MANGOOLA OPEN CUT

8th November 2016

Mangoola Coal Project, Section 75W Modification Application

FIGURE A2.1

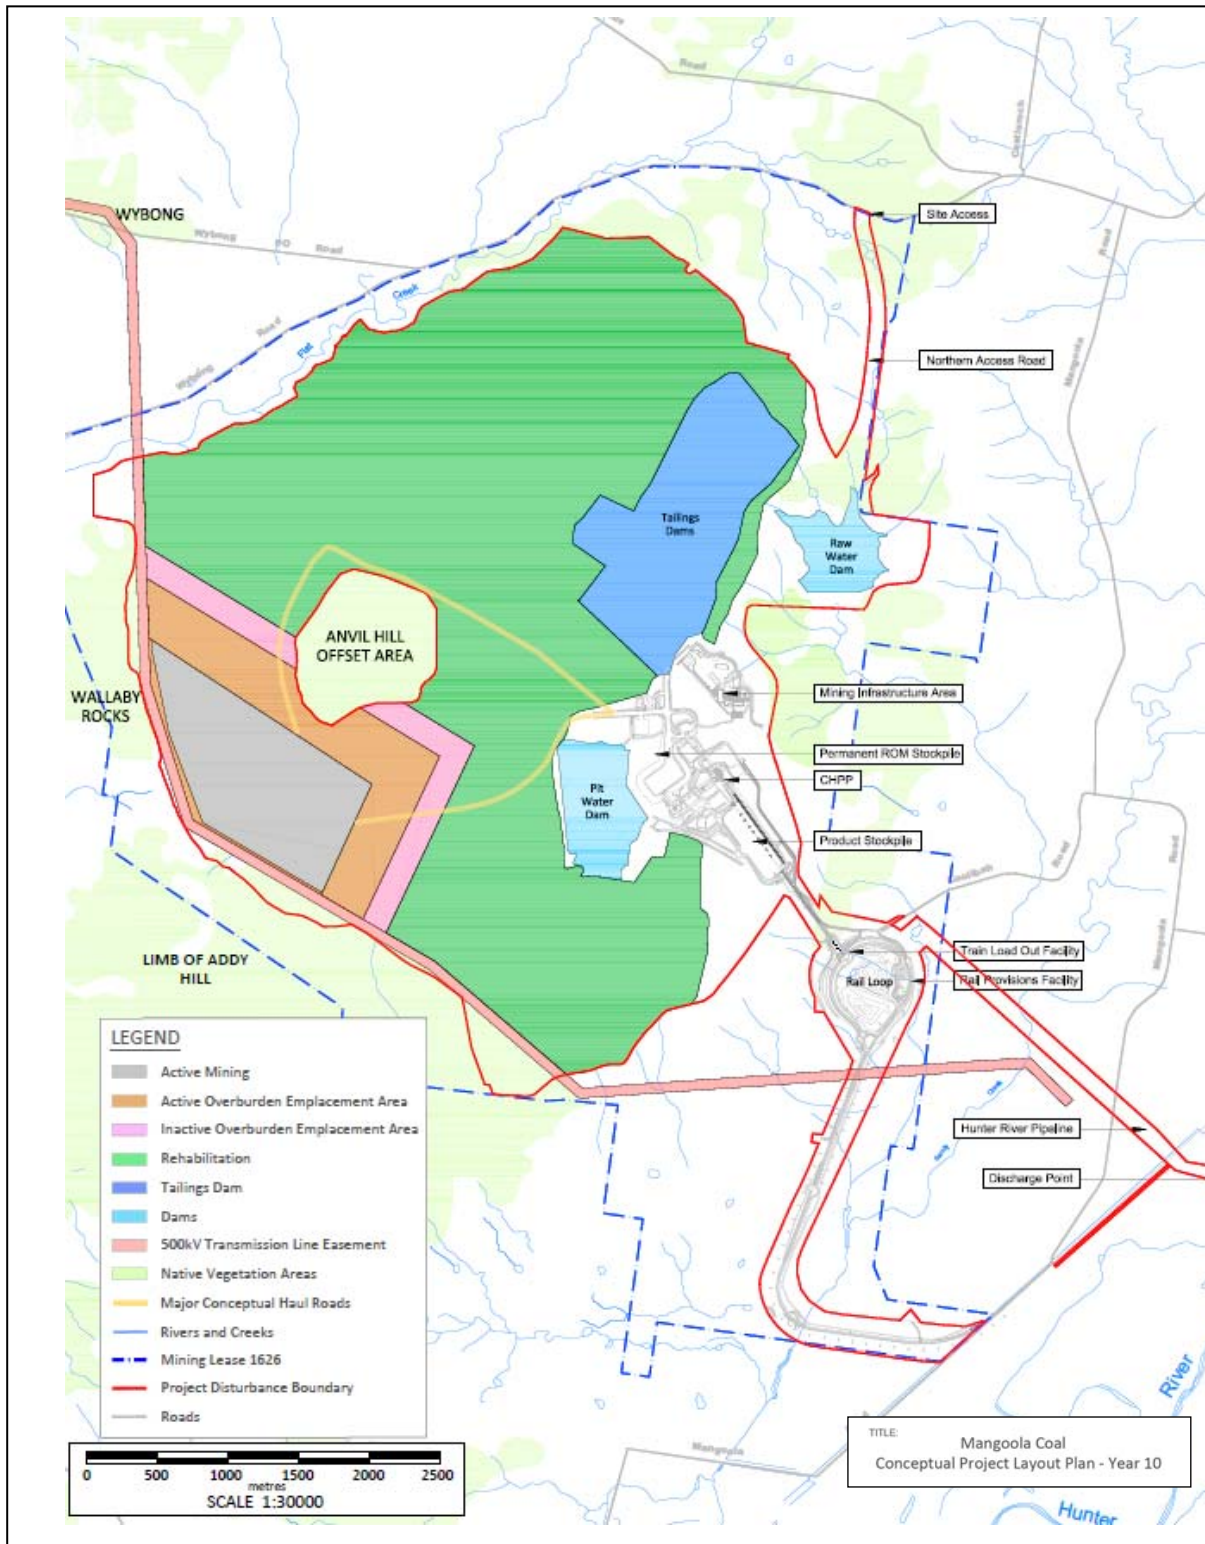
Consequently MCO requests the Minister or delegate to modify the Project Approval to correct the current minor misdescription of the project by substituting the current Project Layout Plan included in Appendix 2 of the Project Approval, with the Project Layout Plan contained at **Annexure A** to this letter. The enclosed Project Layout Plan is a representation of the general layout of the Mangoola Coal Project as currently approved pursuant to the Project Approval, as modified. The layout of the Mangoola Coal Project as shown in the enclosed plan is consistent with the Project Approval, and generally in accordance with the Environmental Assessments (**EAs**) prepared to date in respect of the project. Consequently no additional environmental assessment is required in respect of this application.

- 1 Correct the current minor misdescription of the project shown by the plan in Appendix 2 of the Project Approval, by substituting the current Project Layout Plan in Appendix 2 of the Project Layout Plan with the **enclosed** Project Layout Plan; and
- 2 Substitute the current conditions 2 and 2A of the Project Approval with the following:
 2. *The proponent must carry out the project generally in accordance with the:*
 - (a) EA;
 - (b) EA (MOD 1);
 - (c) EA (MOD 2);
 - (d) EA (MOD 3);
 - (e) EA (MOD 4);
 - (f) EA (MOD 5);
 - (g) EA (MOD 6);
 - (h) EA (MOD 7); and
 - (i) the Project Layout Plan.
